Application No: AW/197/20/PL

Recommendation Report for Planning Permission

LOCATION: The Former Ship Inn
Aldwick Street
Aldwick
PO21 3AP

PROPOSAL: Variation of conditions 8-concerning hours of deliveries & 10- types of vehicles making deliveries following AW/211/14/PL. This application is in CIL Zone 4 (Zero Rated) as 'other development'.

Client
Surplus Property Investments
Project
The Former Ship Inn, Aldwick Street, Bognor Regis. PO21 3AP
Title
Vehicle Tracking : Cars Passing Delivery Vehicles
Scale
1:500 @ A1
Date
21.07.2020
Drawn By
PAL
Checked By
PM
Project No:
B200038
Drawing No:
B 204
Revision
-

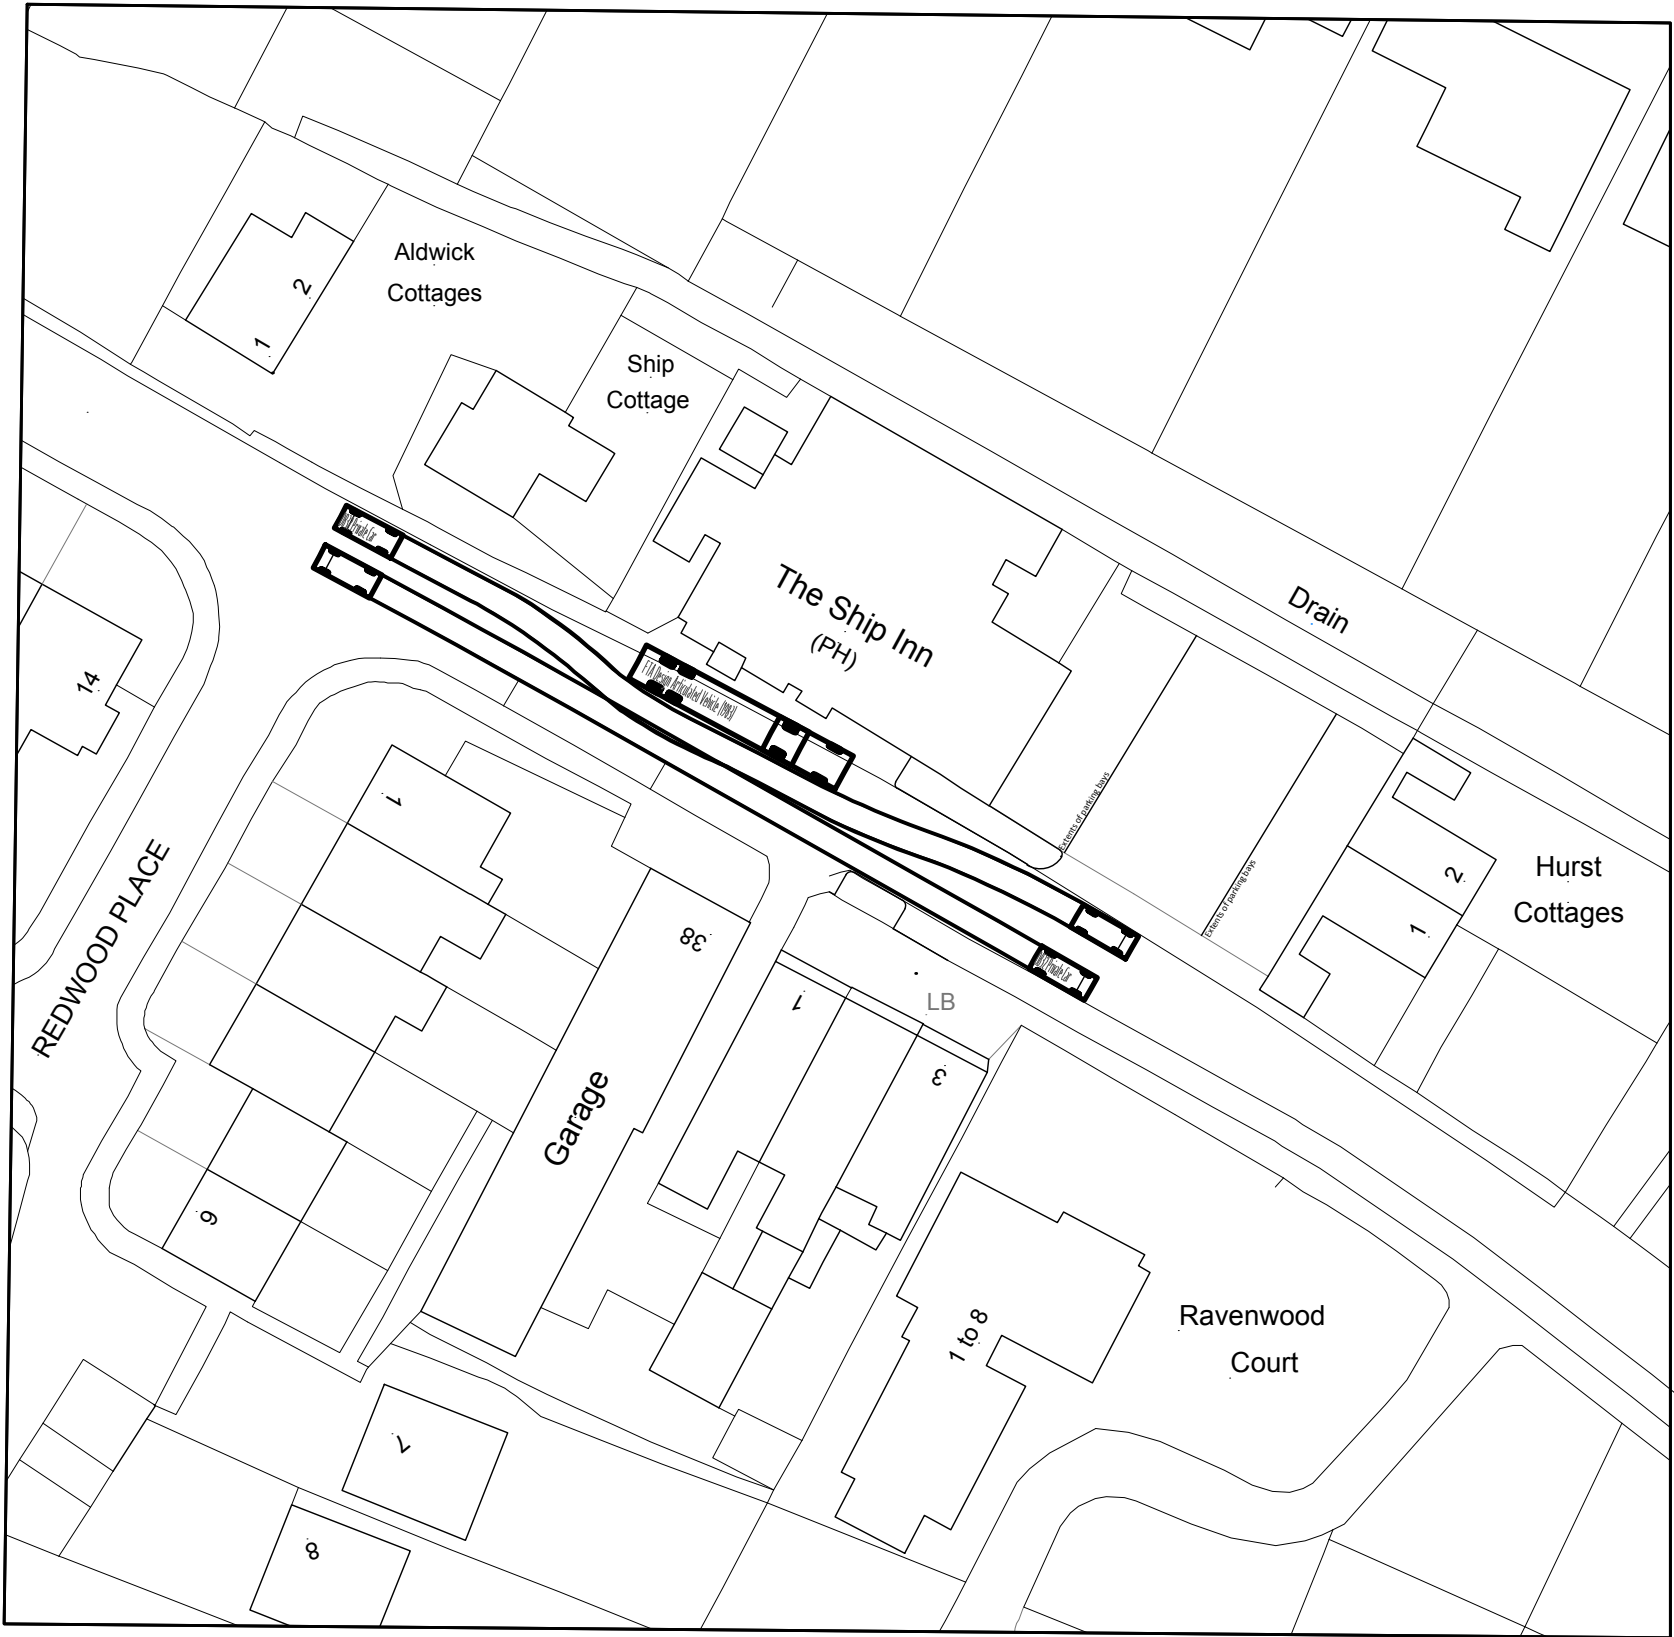
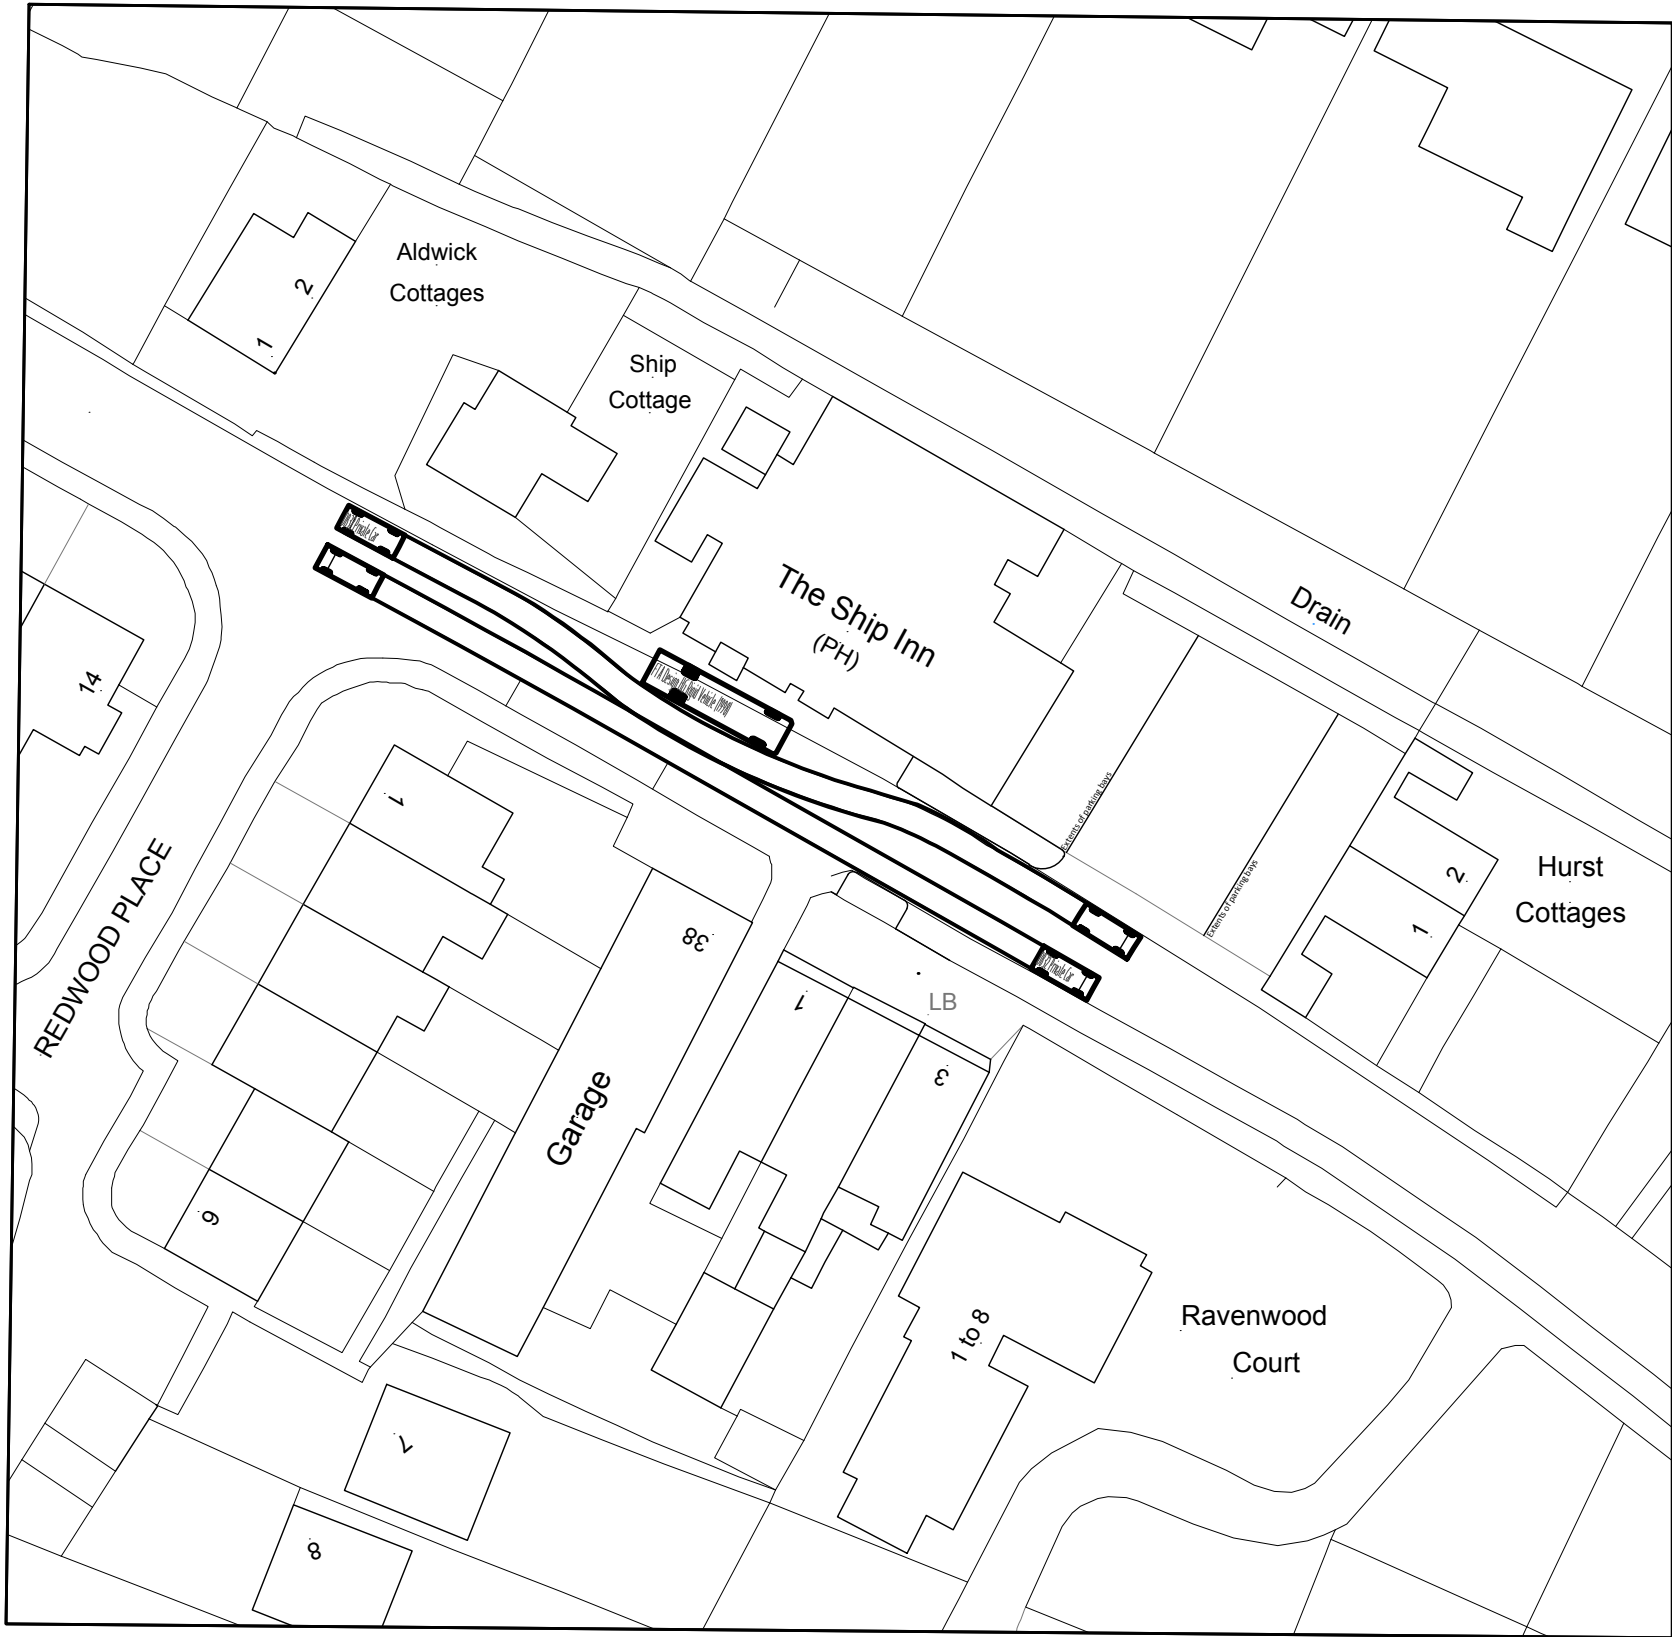
- The changes make no difference to residential amenities of neighbouring properties;
- Changes result in increased larger vehicles;
- Diagrams of vehicles passing delivery vehicles in the "delivery loading bay" omit to show the parking spaces opposite are often occupied by other cars;
- The reason for using larger vehicles is related to the distribution strategy not to the efficiency of local deliveries therefore in conflict with Arun Local Plan policy T SP1;

- Tracking plans show the full extent of the parking bays and it is not necessary for vehicles to be shown in these as it would make no difference to the tracking drawings B101 and B202. These drawings indicate some parked cars in these bays;
